REPORT OF GEOTECHNICAL EXPLORATION

KUM & Go #2232

SECURITY BOULEVARD AND MAIN STREET
EL PASO COUNTY, CO

December 7, 2021
Olsson Project No. 021-05598

DATE: 05-11-2023
 SHEET NUMBER: C4.1
 17 OF 43

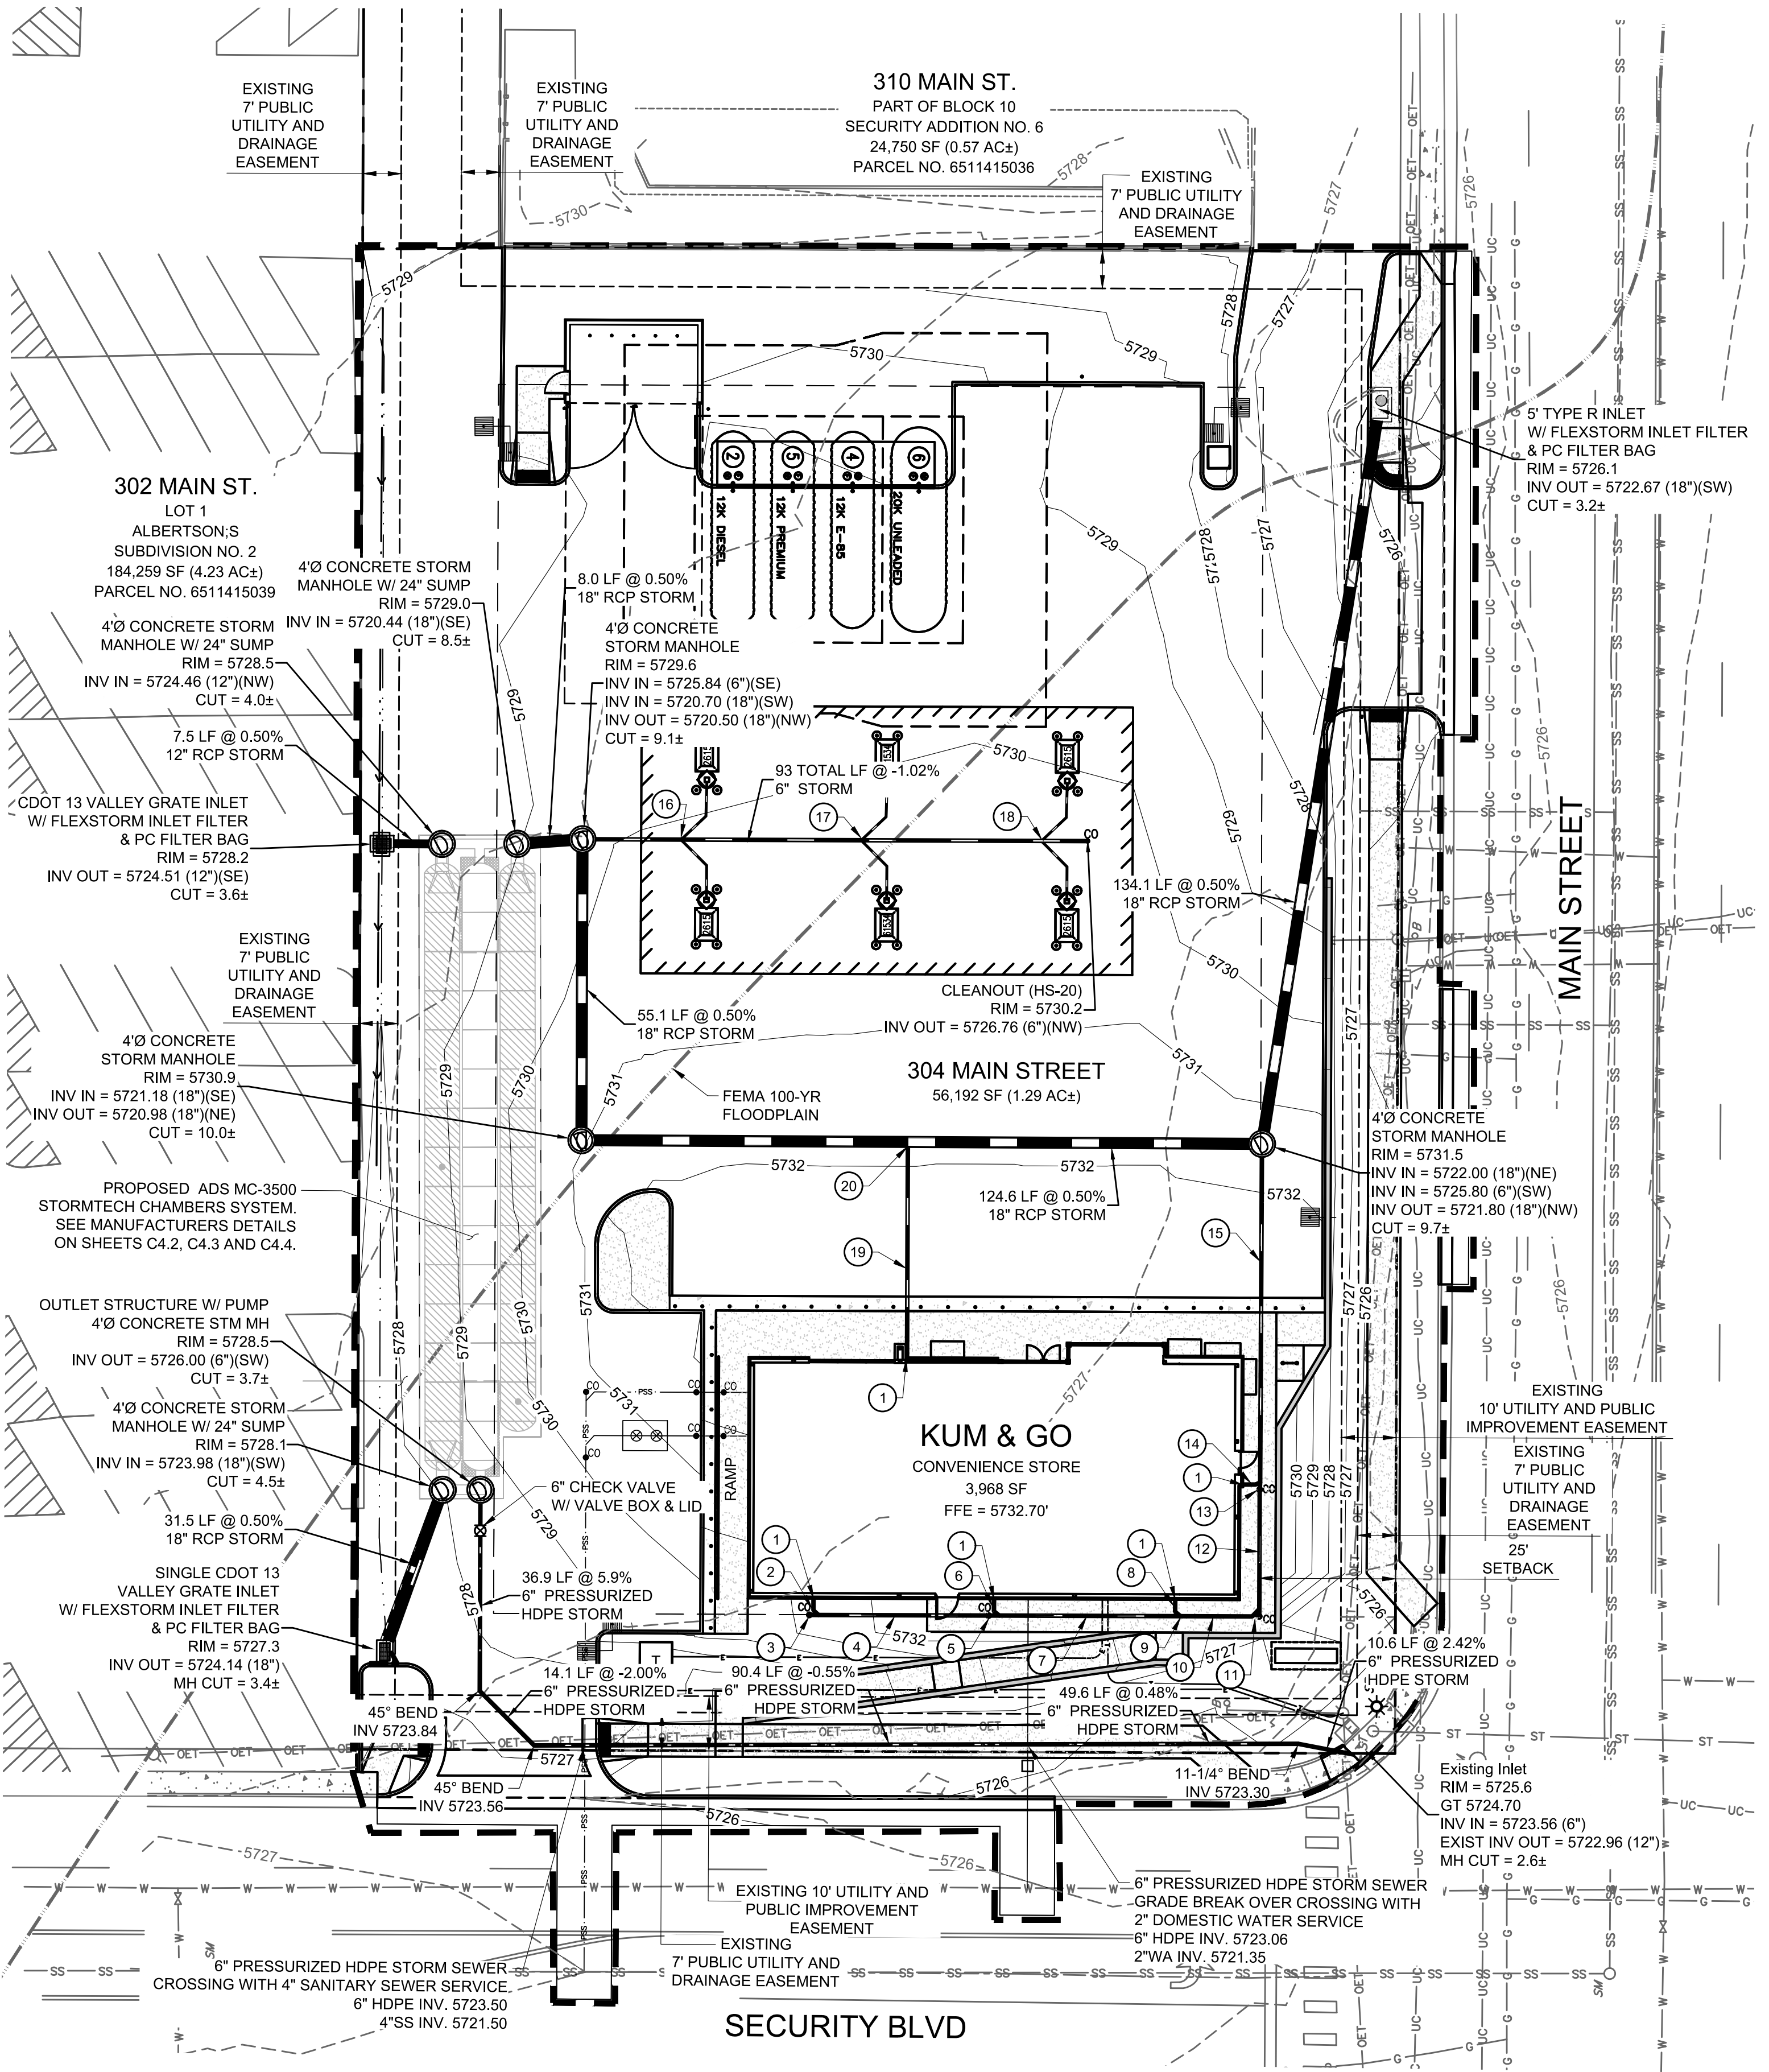
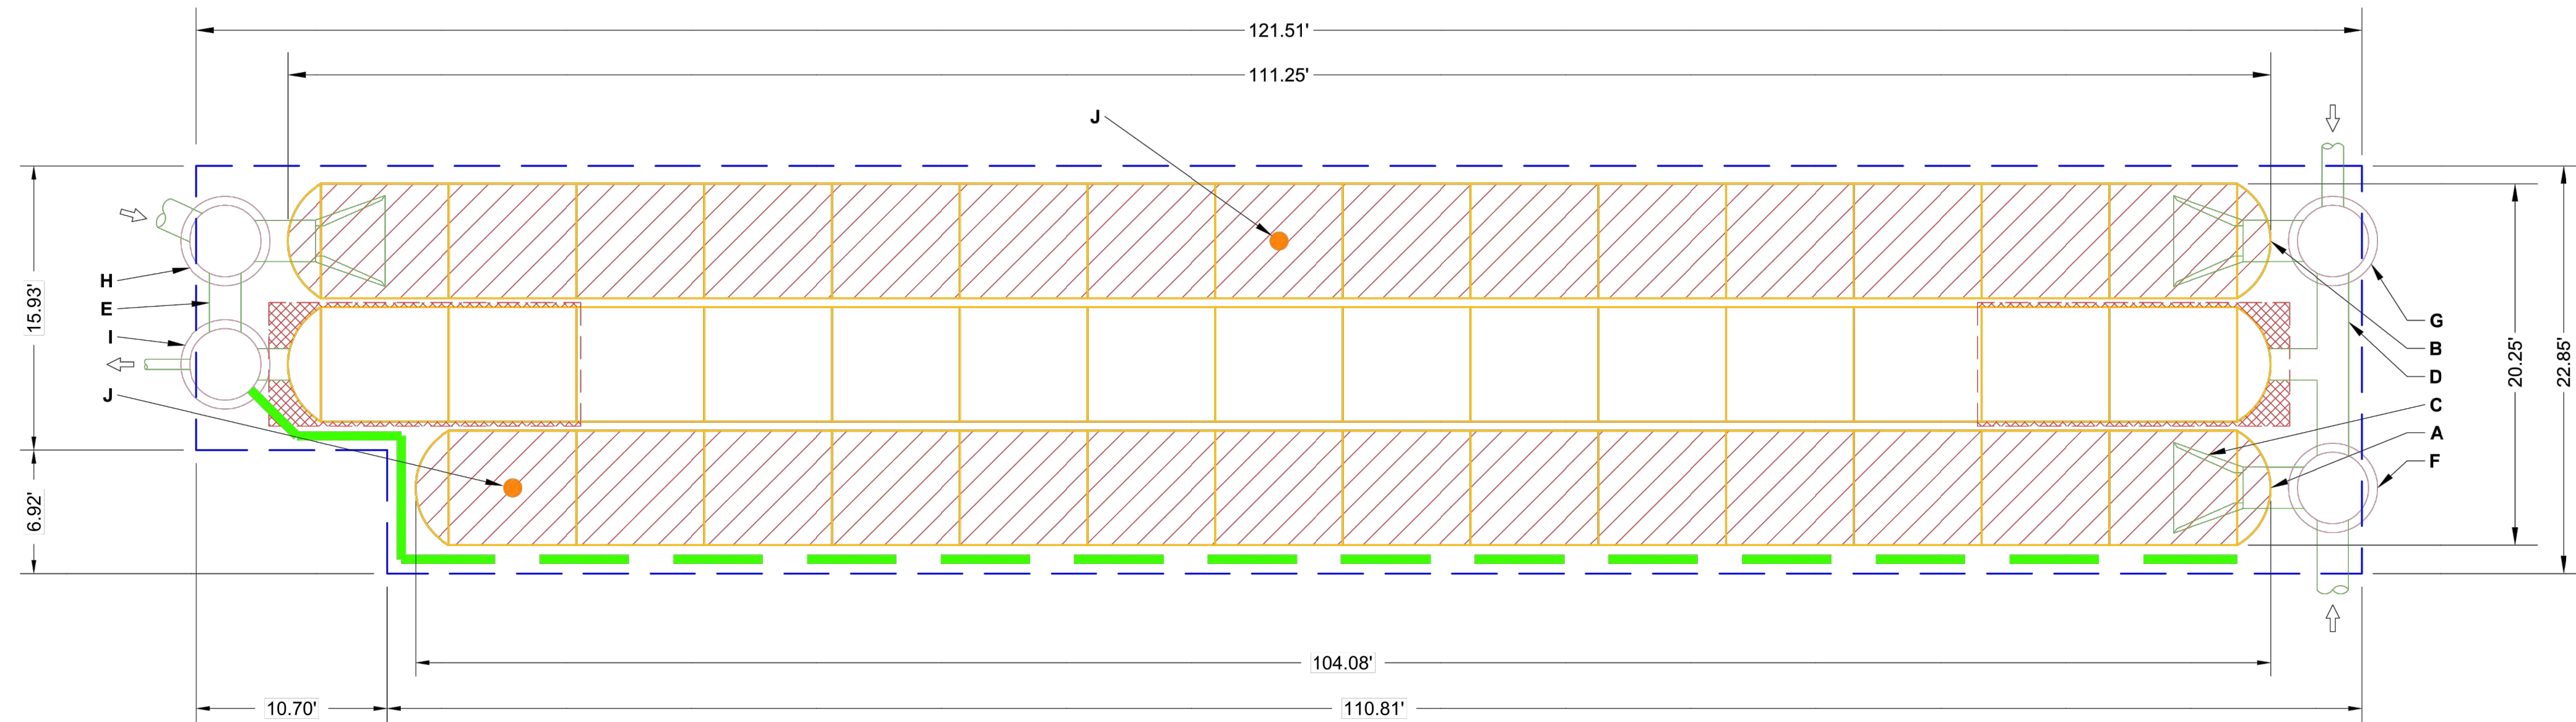
Soils report does not address infiltration for underground WQ structure. It also doesn't address the impact this infiltration (and additional groundwater) will have on the surrounding soils and structures (including pavement). Address in here or in drainage report.
